Ref:
SSD-82709458

RE: SUBMISSION TO SSD-82709458, Residential development with infill affordable housing
Address: 19-25 Balfour Street, Lindfield

Ku-ring-gai Council's objection to SSD- 82709458, 19-25 Balfour Street, Lindfield

1 **OVERSHADOWING - 9AM JUNE 21 (EXISTING)**
1 : 1000

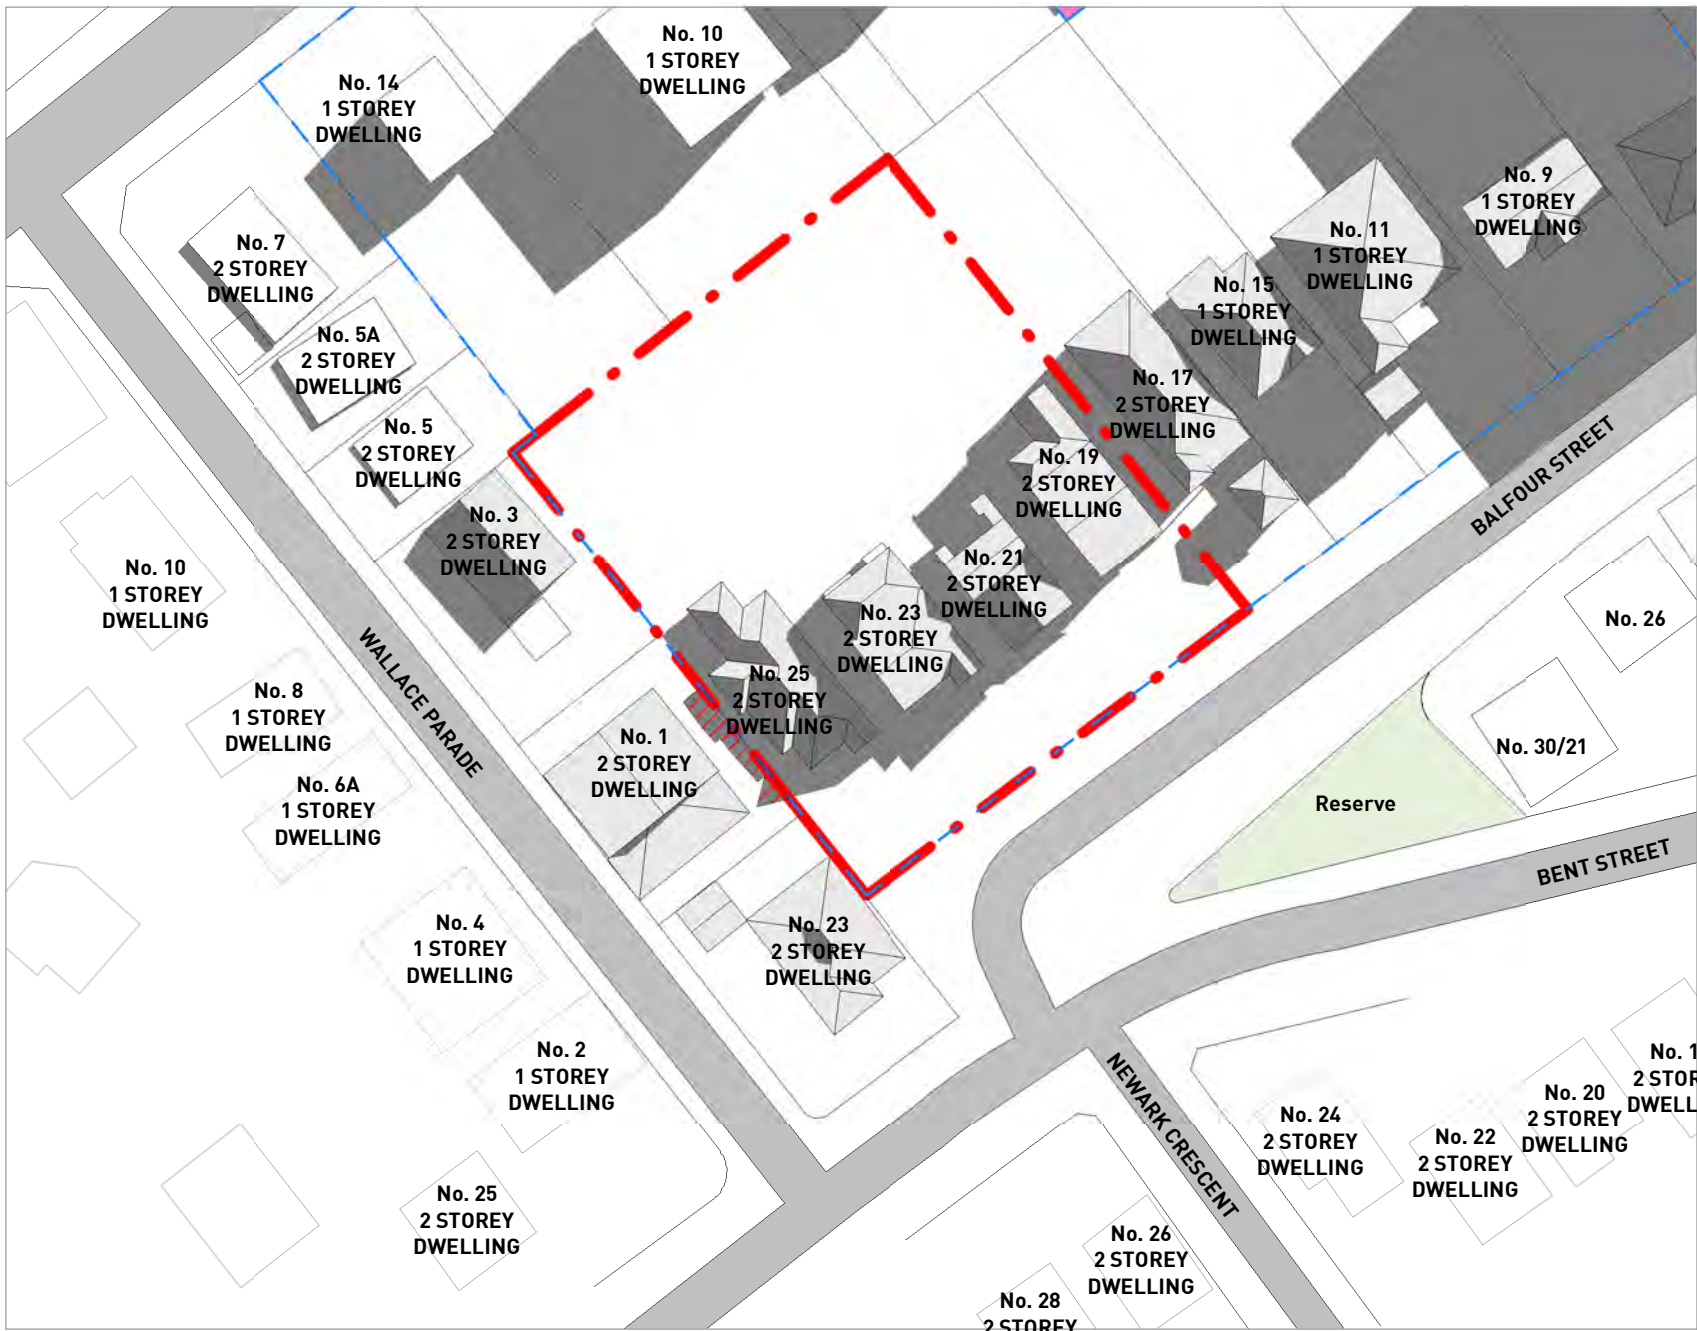
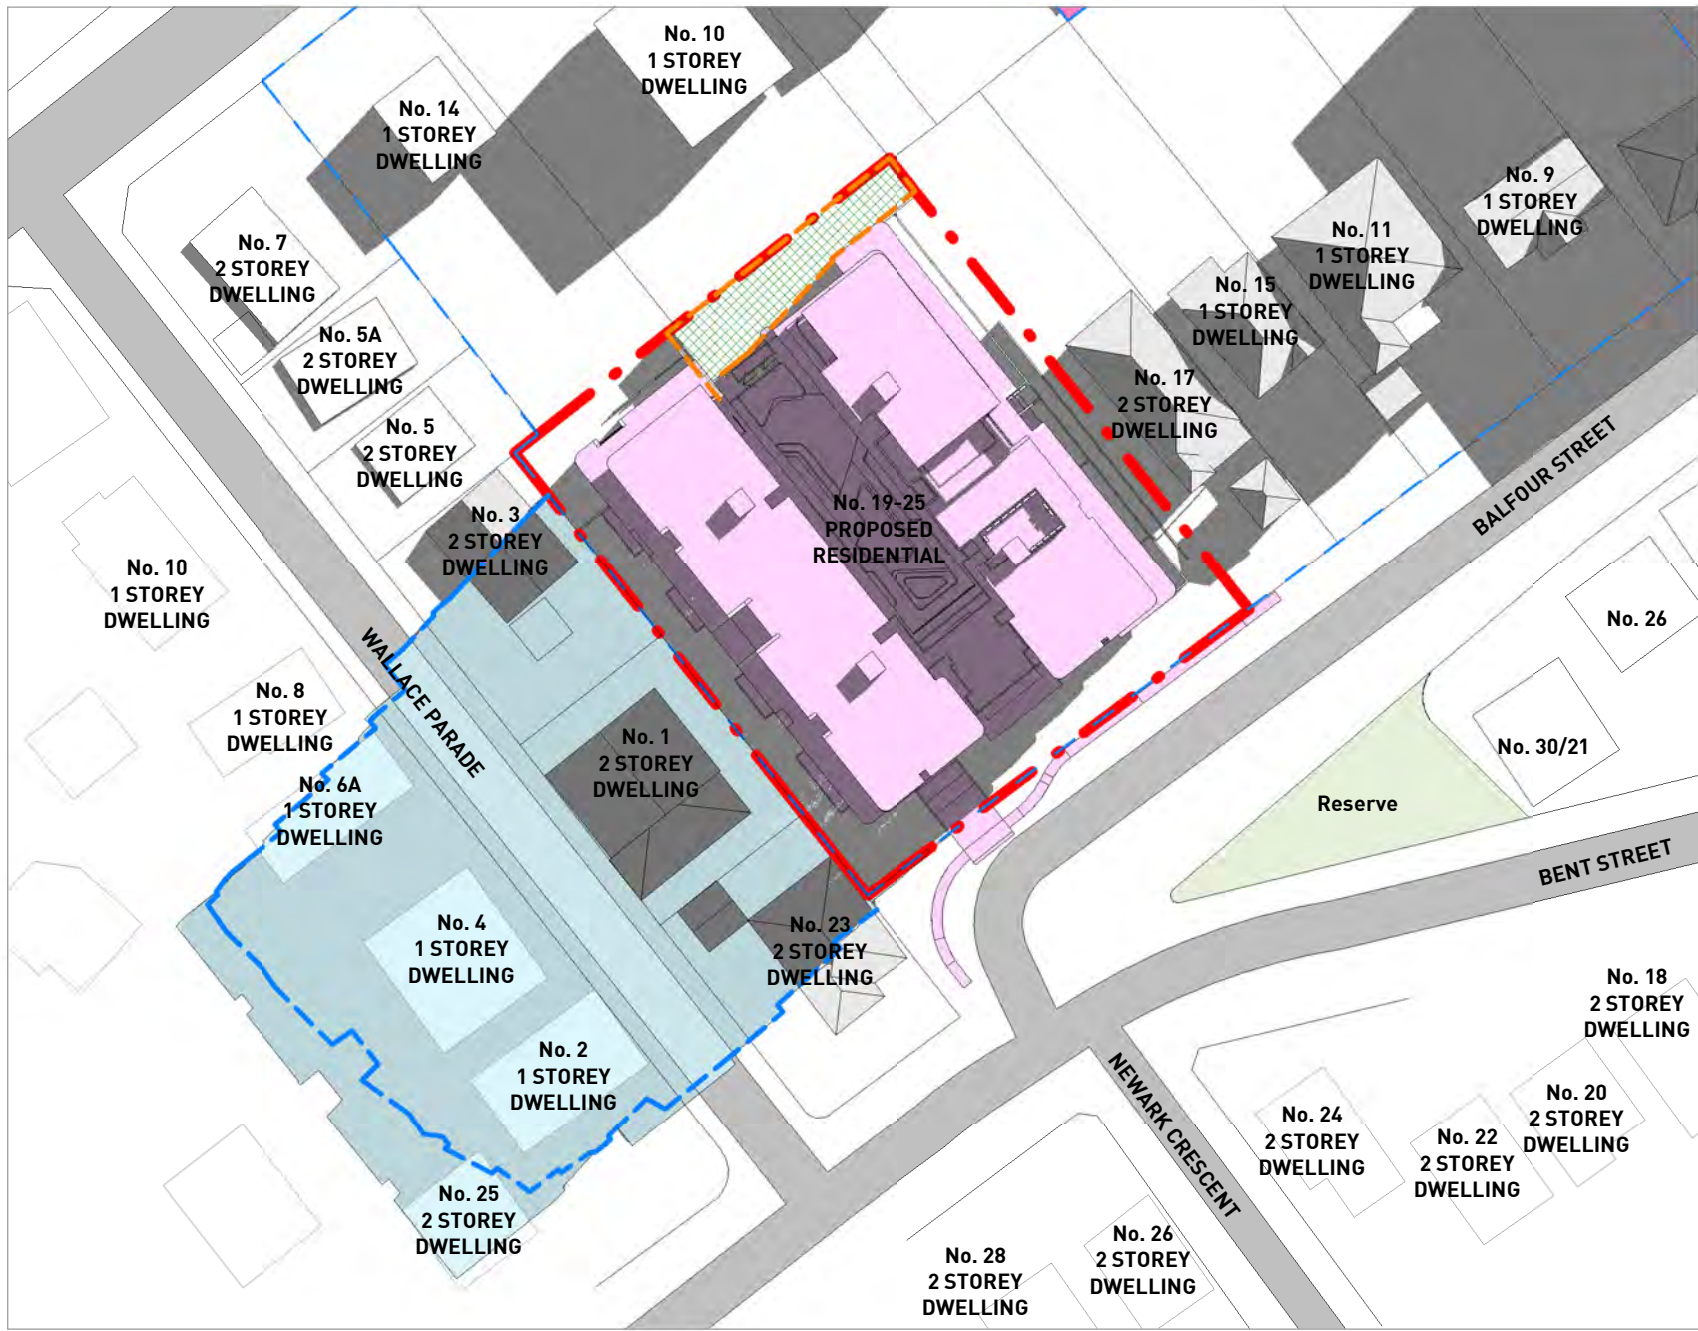
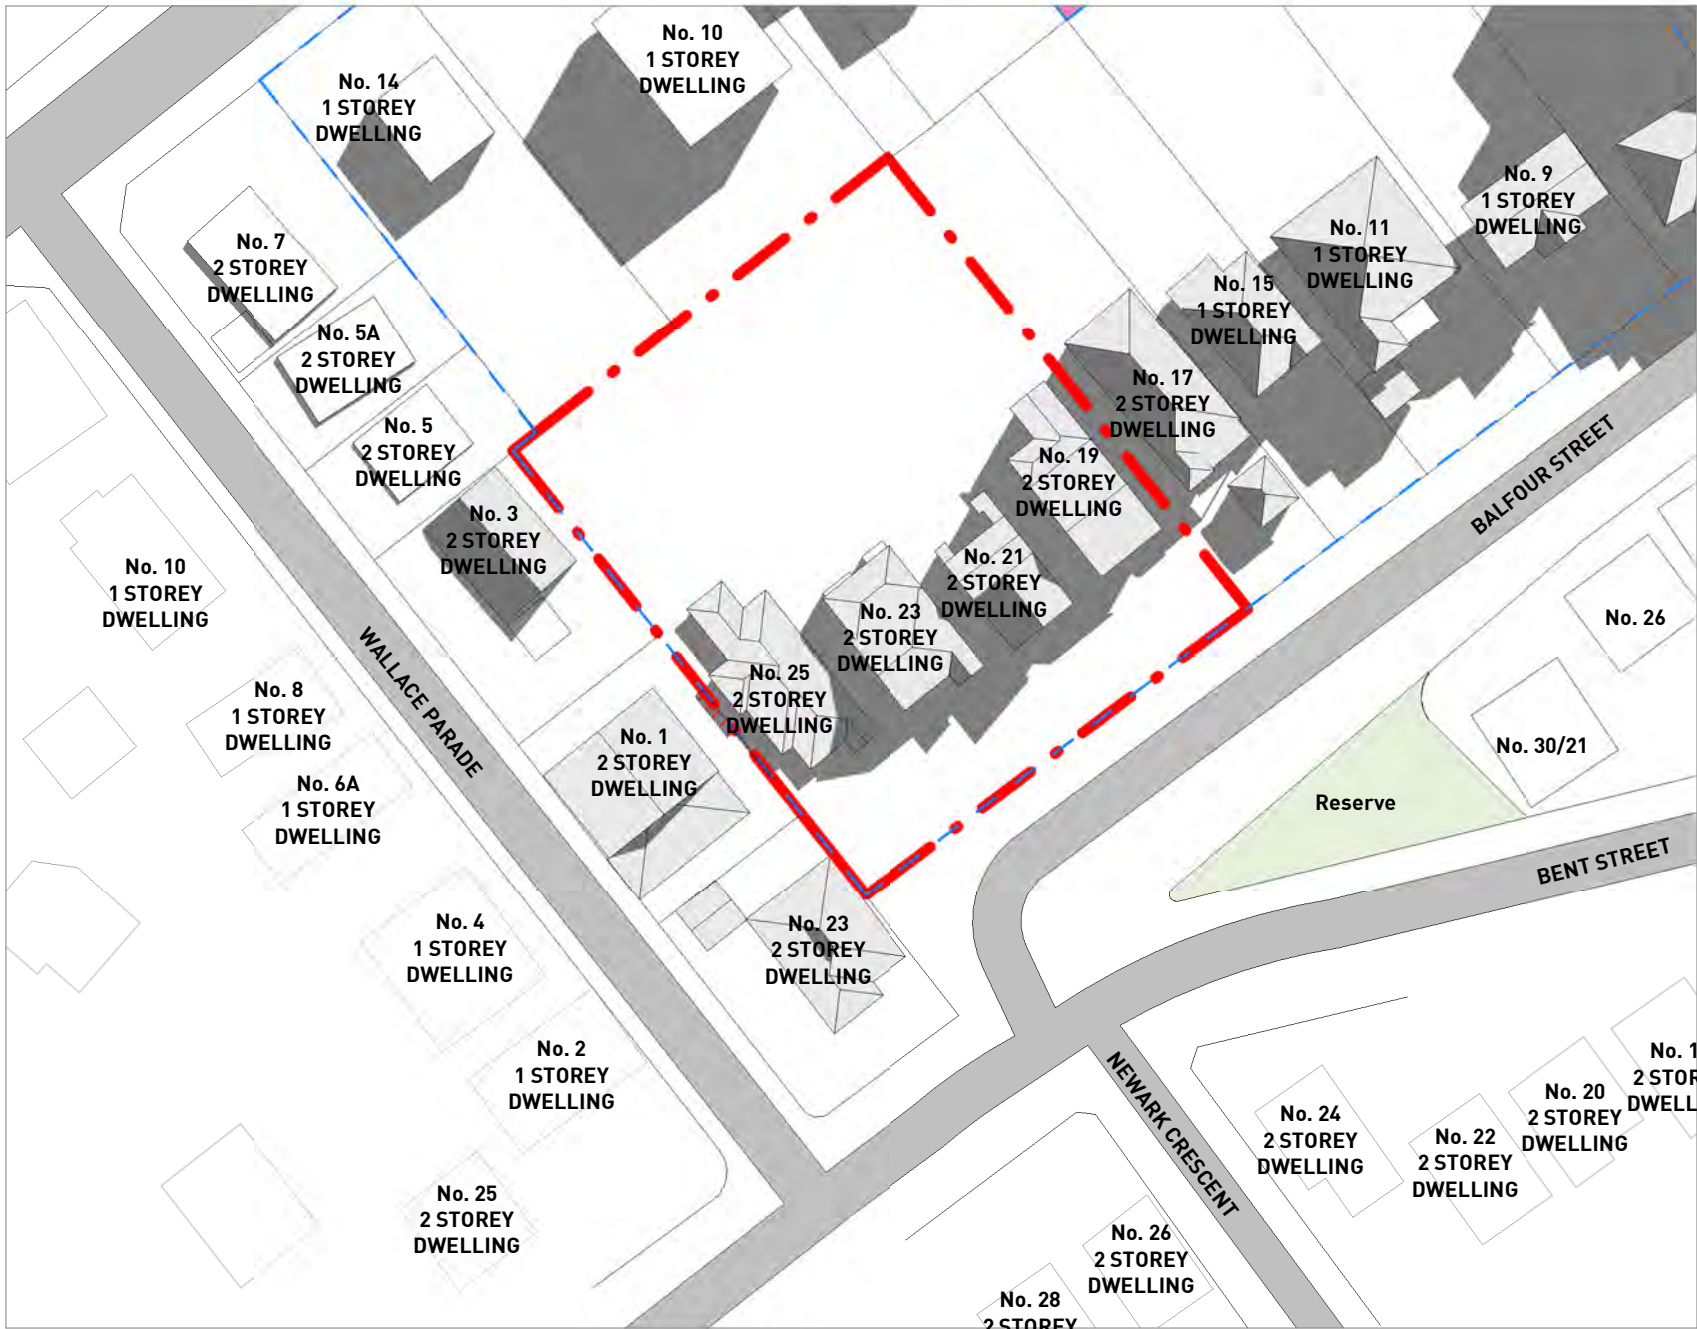
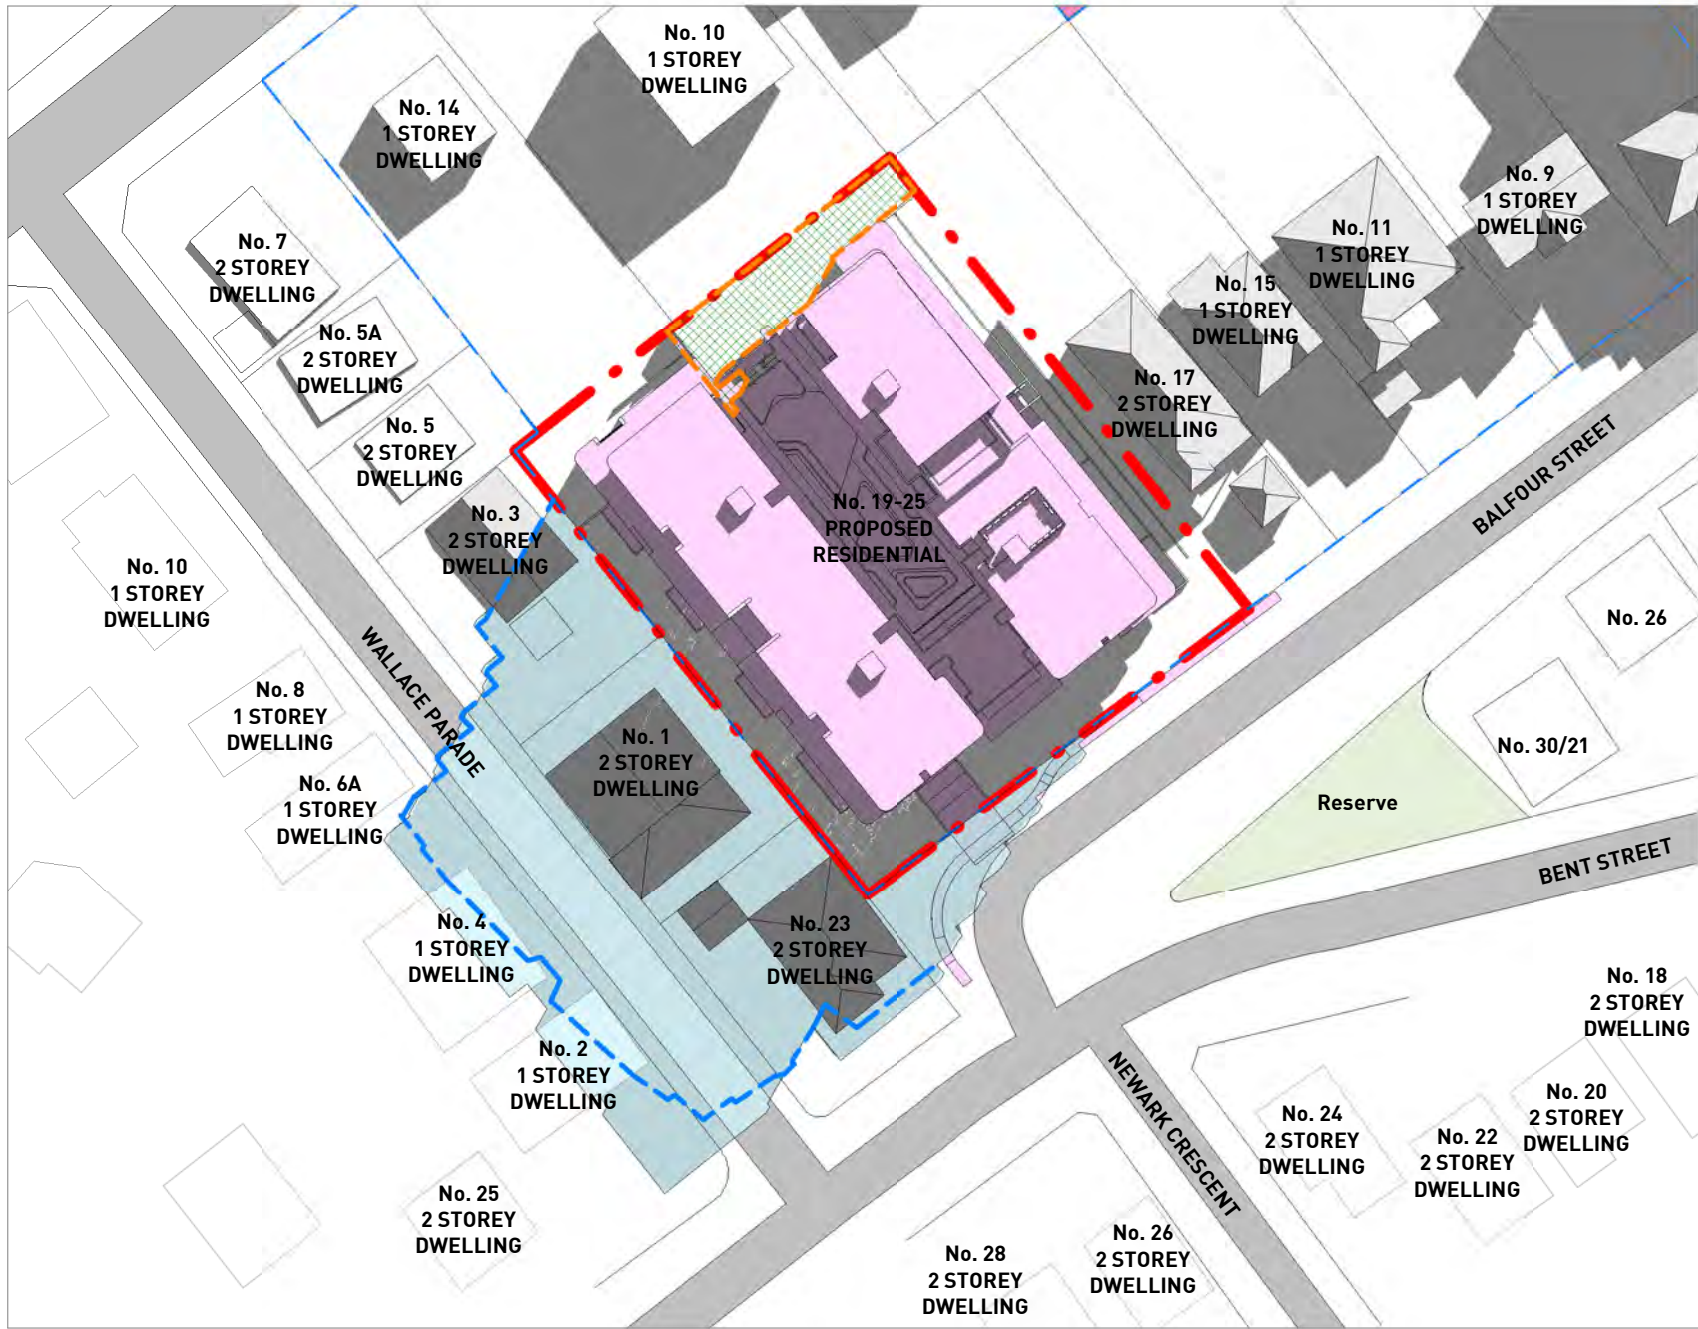
The site slopes to the south-west, exacerbating overshadowing impacts on neighbouring properties. The dwellings at 23 Bent Street and 1 Wallace Parade are in partial or full shadow until 2pm, leaving only one hour of sunlight (2–3pm). This represents a significant shortfall in solar access relative to the ADG's objectives. Importantly, the proposal does not comply with setbacks along the western elevation at the 10 storey and makes no provision for increased separation or setbacks to the west, despite the ADG guidance that these measures should be applied where overshadowing impacts are significant.

The In-Fill Affordable Housing Practice Note (p.12) clearly states: *"The full extent of the in-fill affordable housing bonuses may not be achieved on all sites, due to site constraints and local impacts. The in-fill affordable housing bonuses should not be treated as an entitlement."* Despite this, the submitted Overshadowing Diagrams compare shadows cast by a so-called 'compliant height' form with those of the

proposed scheme. However, the 'compliant' form is taken to be 26.86m, already assuming the affordable housing bonus. This methodology understates the actual impacts, as a true and accurate comparison should be between the 22m control and the proposed scheme.
